Development & Commercial Stormwater Construction Site Inspection Report

General Information			
Project Name	Buglo Apartments		
Owners/Operators Name	Sharif Rabadi / Mohammad Tahat		
Date of Inspection	6/11/2021	Start Time	8:00 am
Inspector's Name(s)	Mohammad Tahat		
Inspector's Title(s)	Inspector / Self inspection		
Inspector's Contact Information	5756500380		
Inspector's Qualifications			
Type of Inspection: <input checked="" type="checkbox"/> Regular <input type="checkbox"/> During storm event <input type="checkbox"/> Post-storm event			
Weather Information			
Has there been a storm event since the last inspection? NO If yes, provide: Storm Start Date: Approximate Amount of Precipitation (in):			
Weather at time of this inspection? <input checked="" type="checkbox"/> Clear <input type="checkbox"/> Cloudy <input type="checkbox"/> Rain <input type="checkbox"/> Sleet <input type="checkbox"/> Snowing <input type="checkbox"/> High Winds <input type="checkbox"/> Partly Cloudy <input type="checkbox"/> Other:

TEMPORARY EROSION AND SEDIMENT CONTROL PLAN

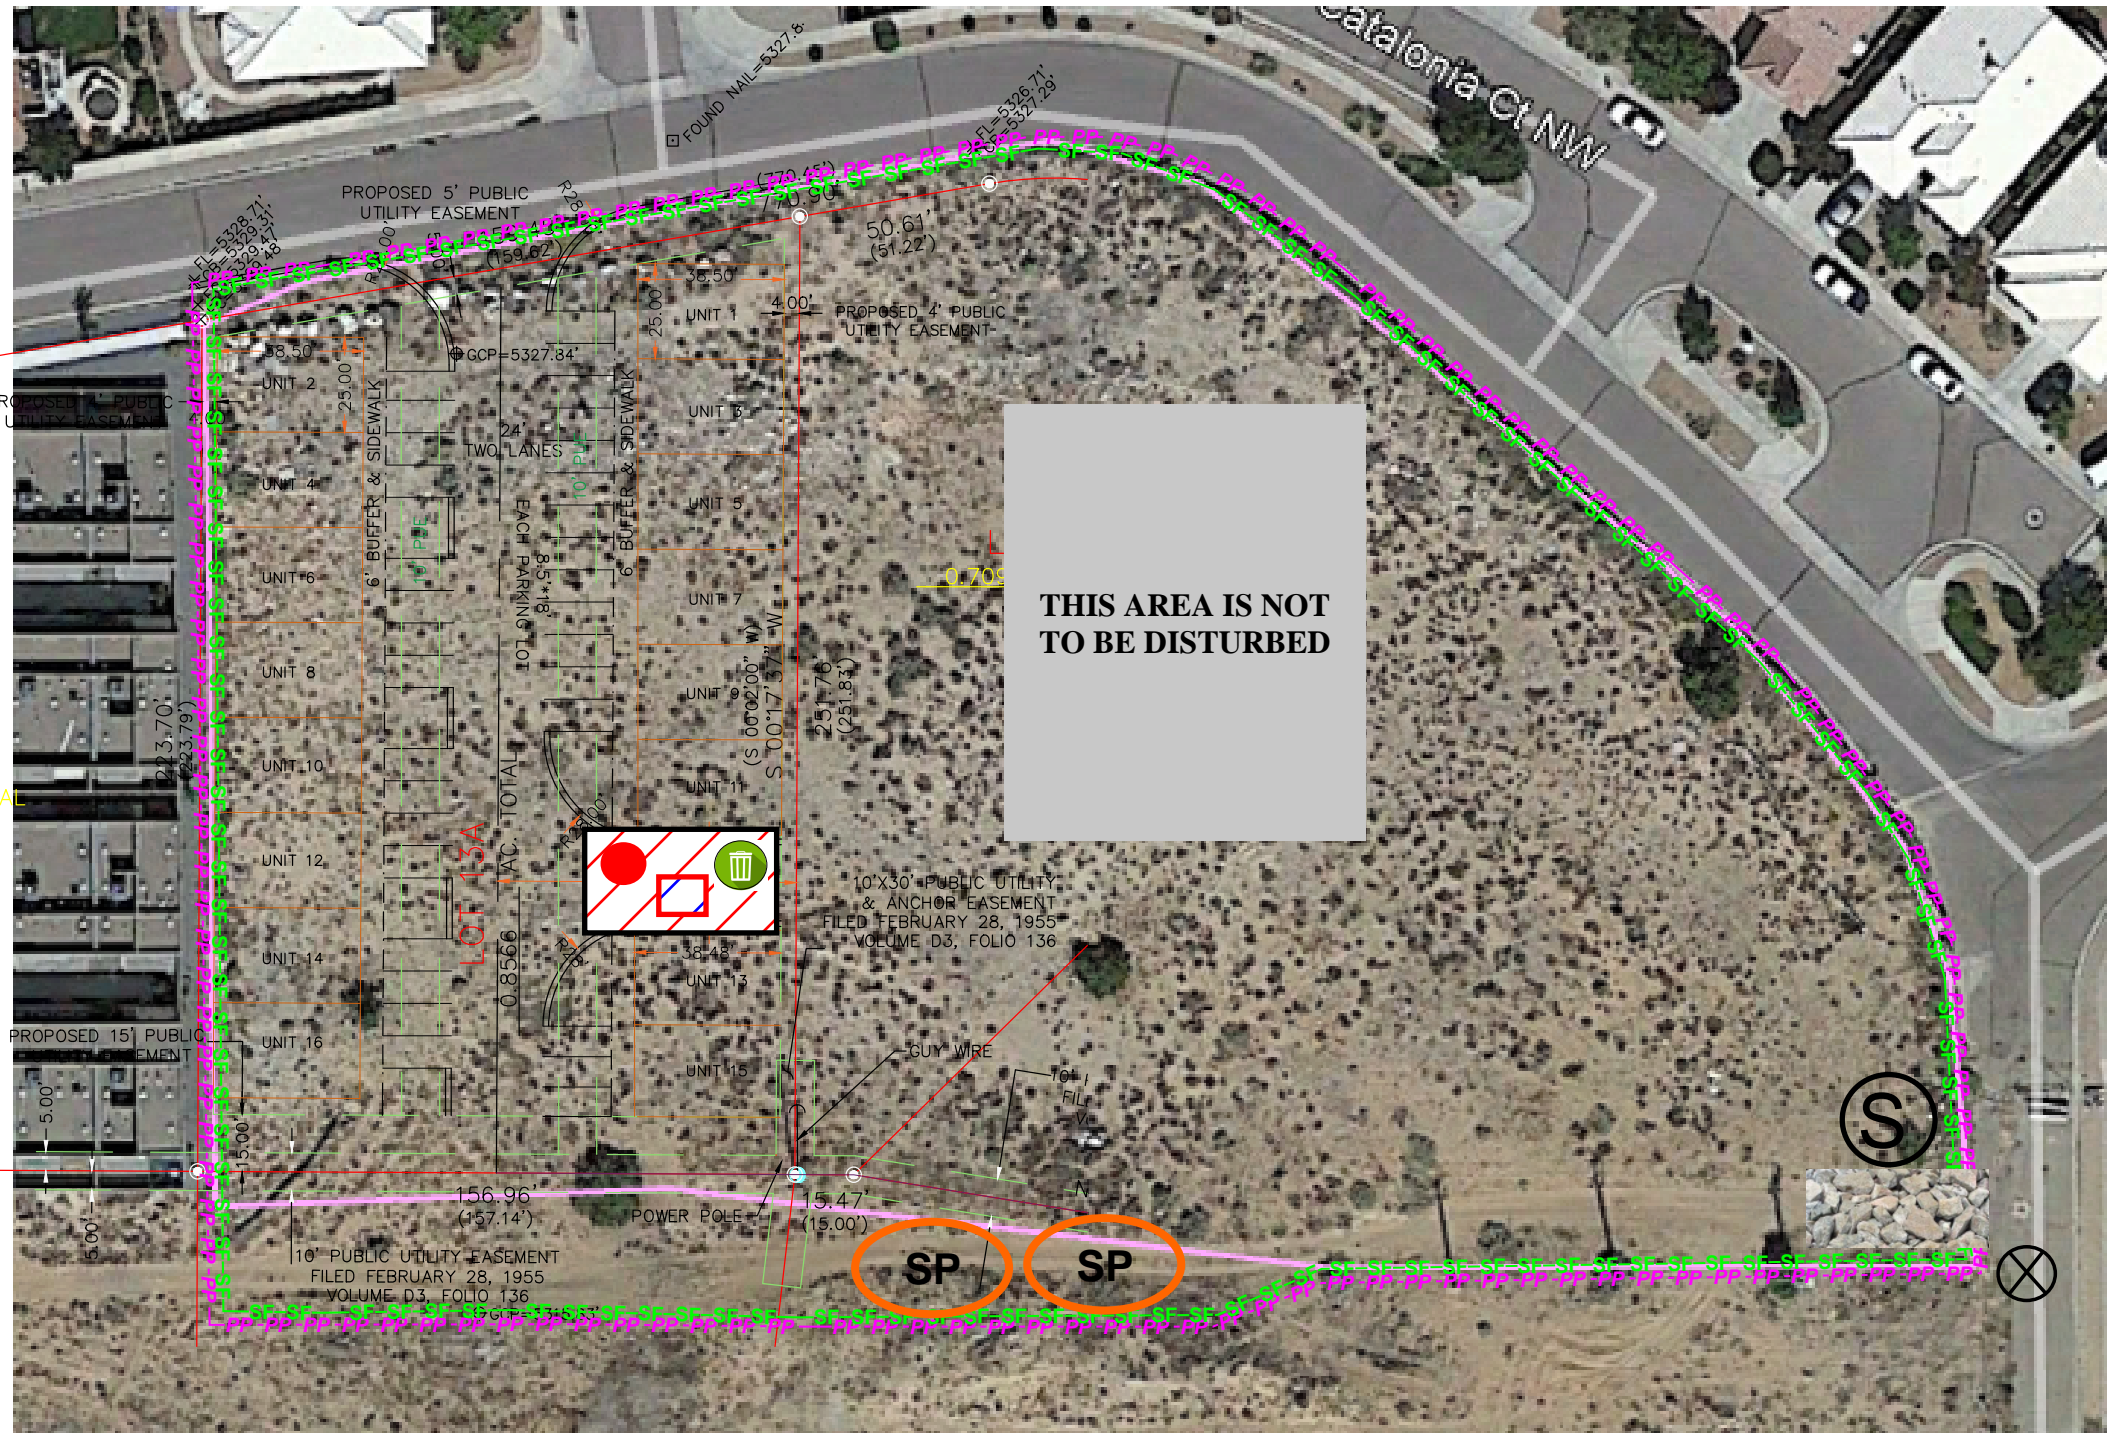
1. The fence on the south bounday need to be changed on the map to match current location because it more appropriate.			
2.			
3.

1	Are the BMPs shown on the map?	yes	
2	Were there changes to the SWPPP?	yes	the fence on the south should be changed on the map
3	Has the SWPPP been updated?	NO	Inspection Plus is working on it
4	Were the changes to the SWPPP implemented within 7 days?	yes
